From: [REDACTED]
Sent: 13 November 2018 13:00
To: Laura Gibbons
Cc: [REDACTED]
Subject: Re: Roundstone Lane, Angmering

Subject: RE: Roundstone Lane, Angmering

Engineers Comments Regarding Condition 6

PLANNING

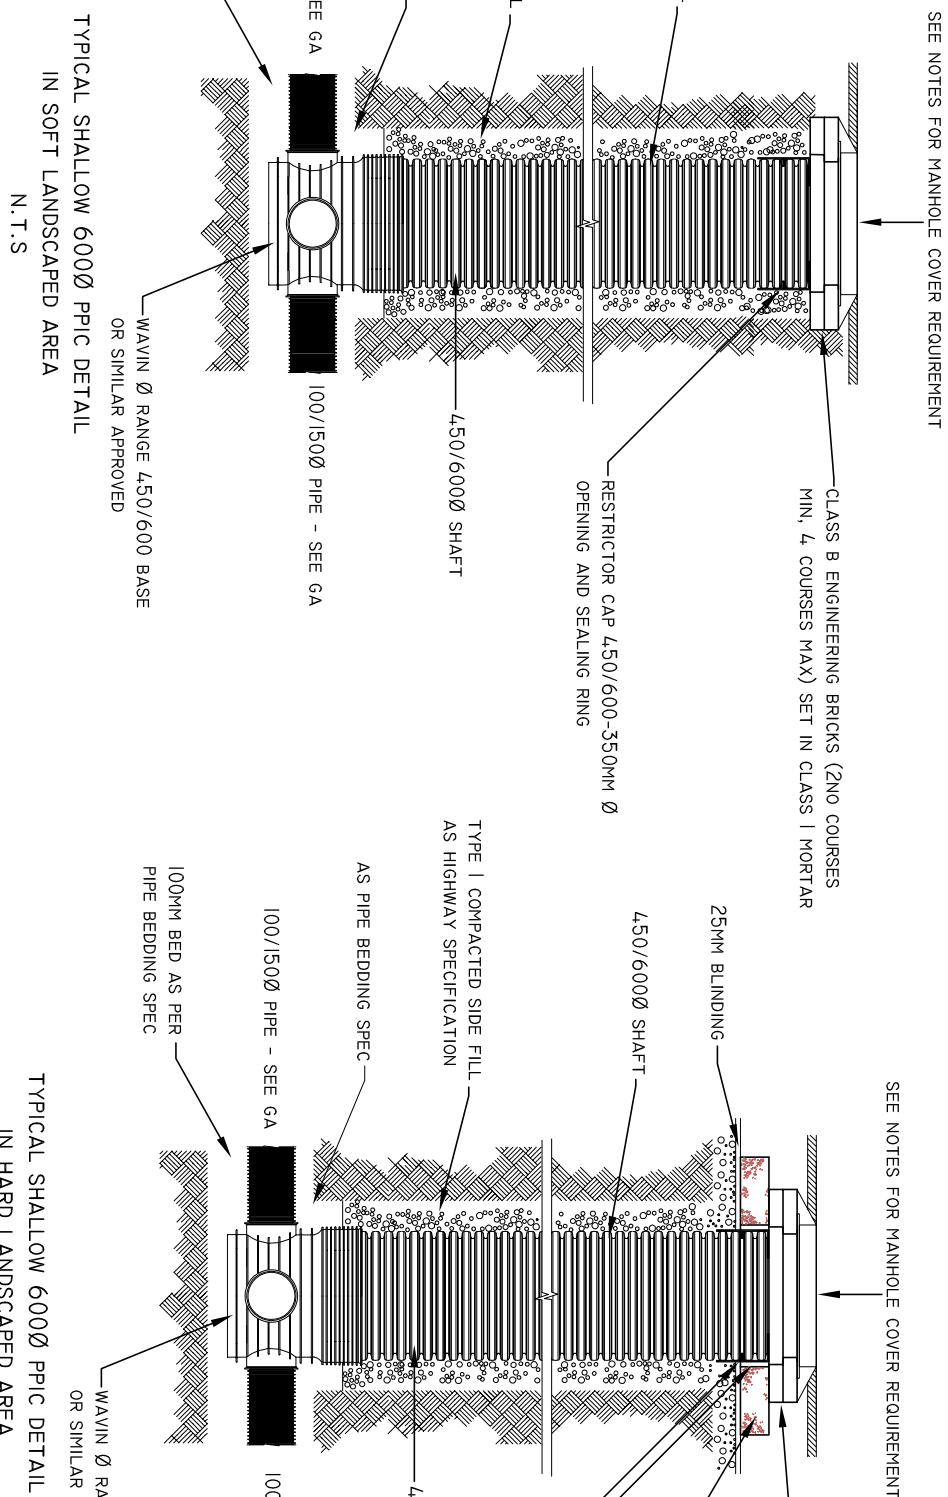
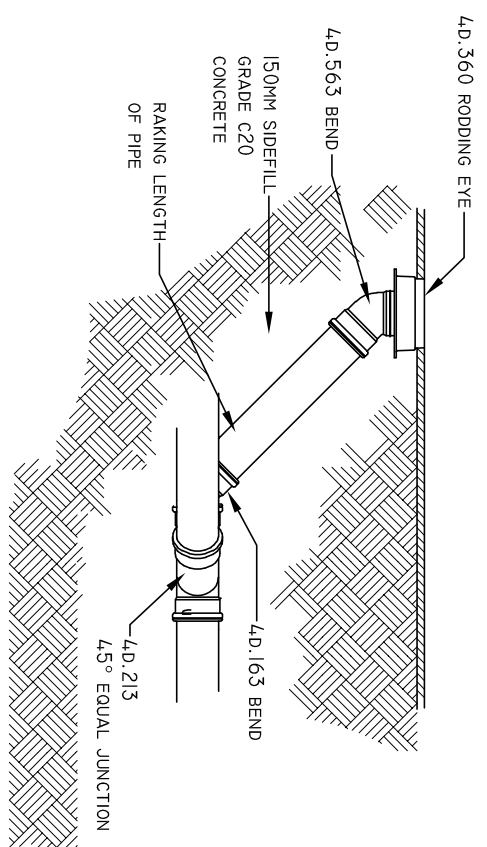
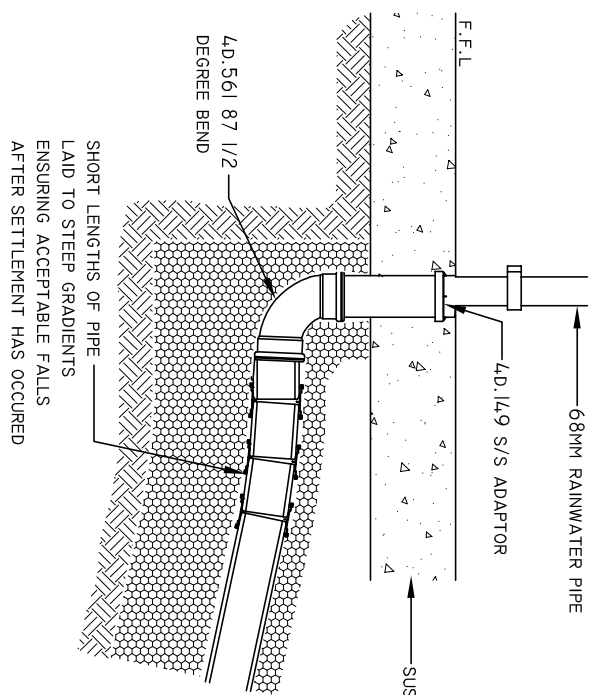
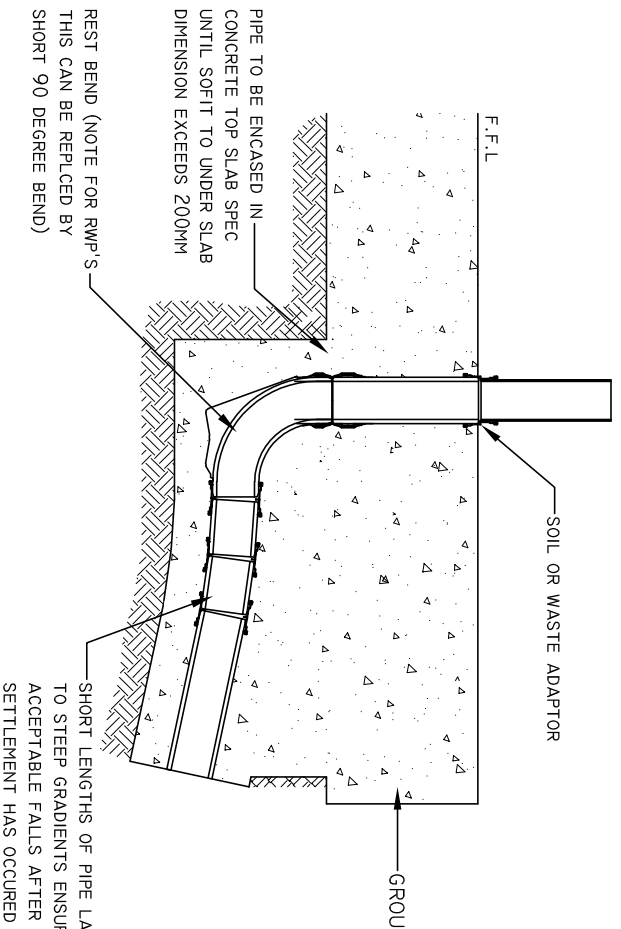
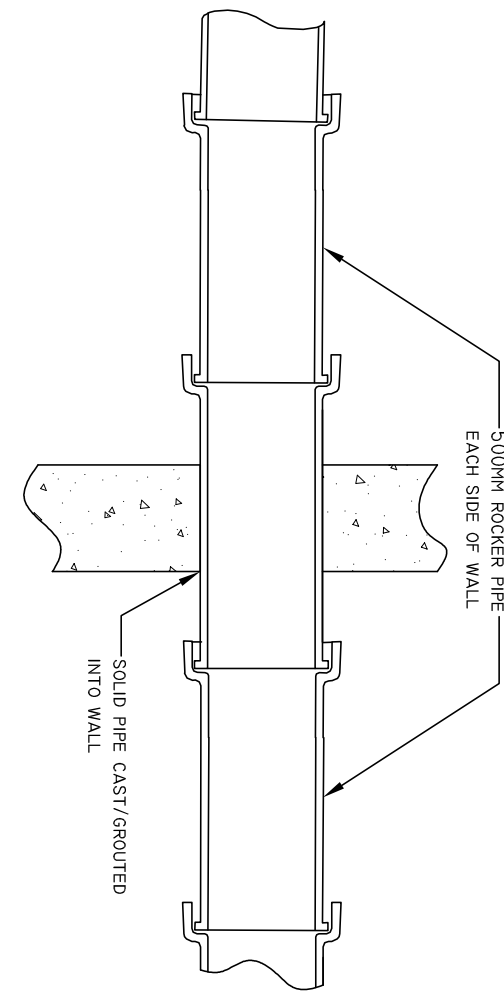
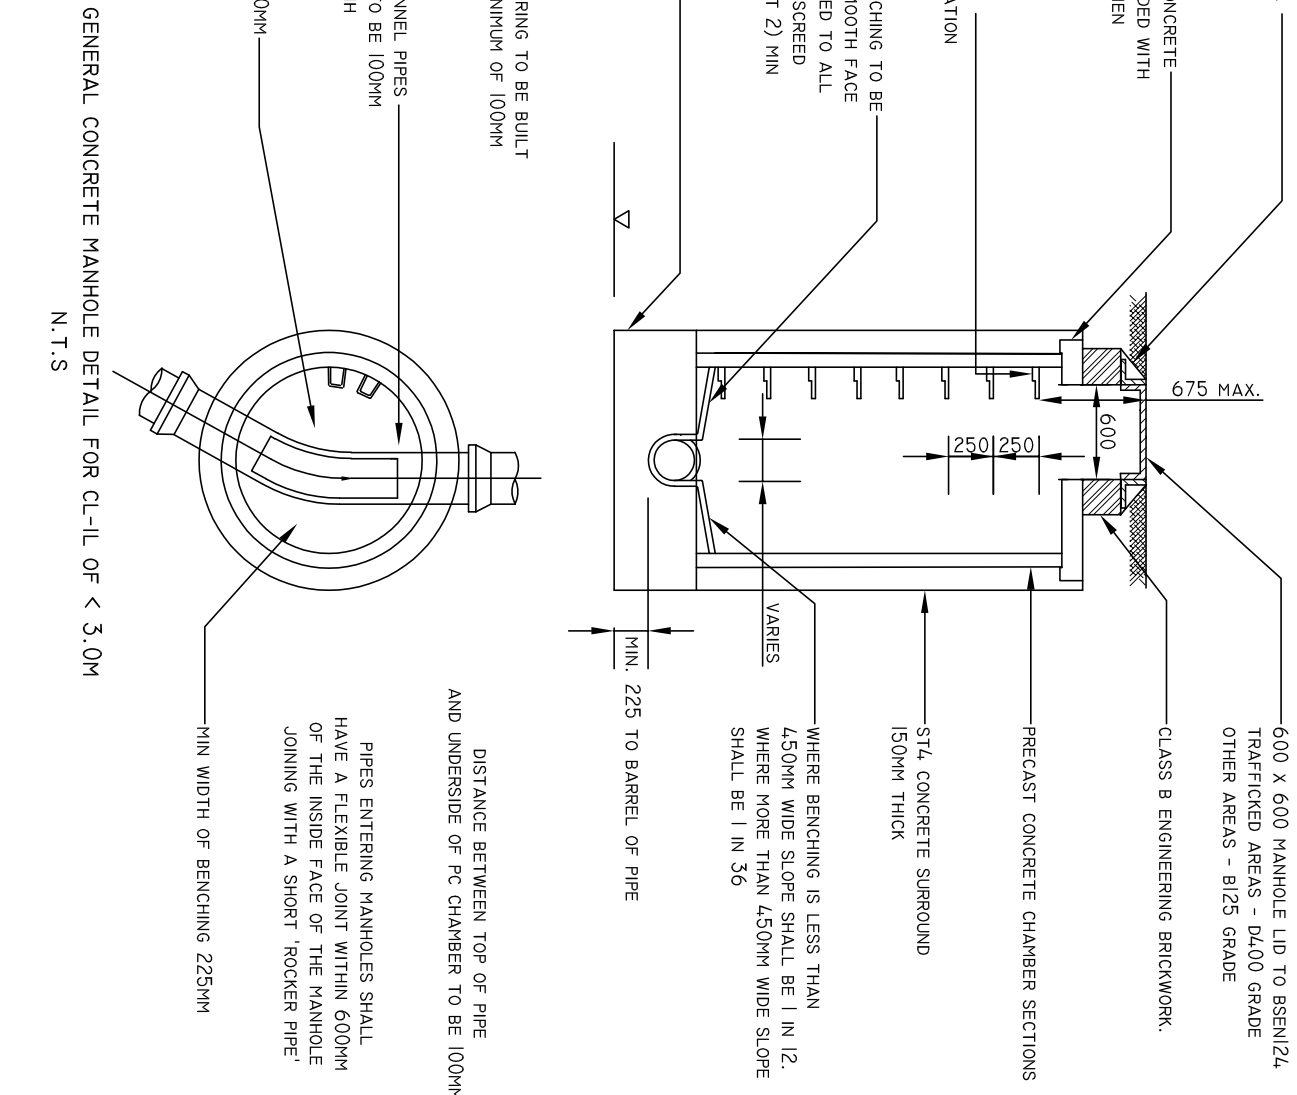
- Please provide justification for the infiltration rate used (6.48 m/hr) for the eastern soakaway.
- What treatment is being provided for the surface water from the road?
- Can construction detail drawings please be provided.

In regards to the construction details please find the relevant drawings attached as well as our latest drainage layout.
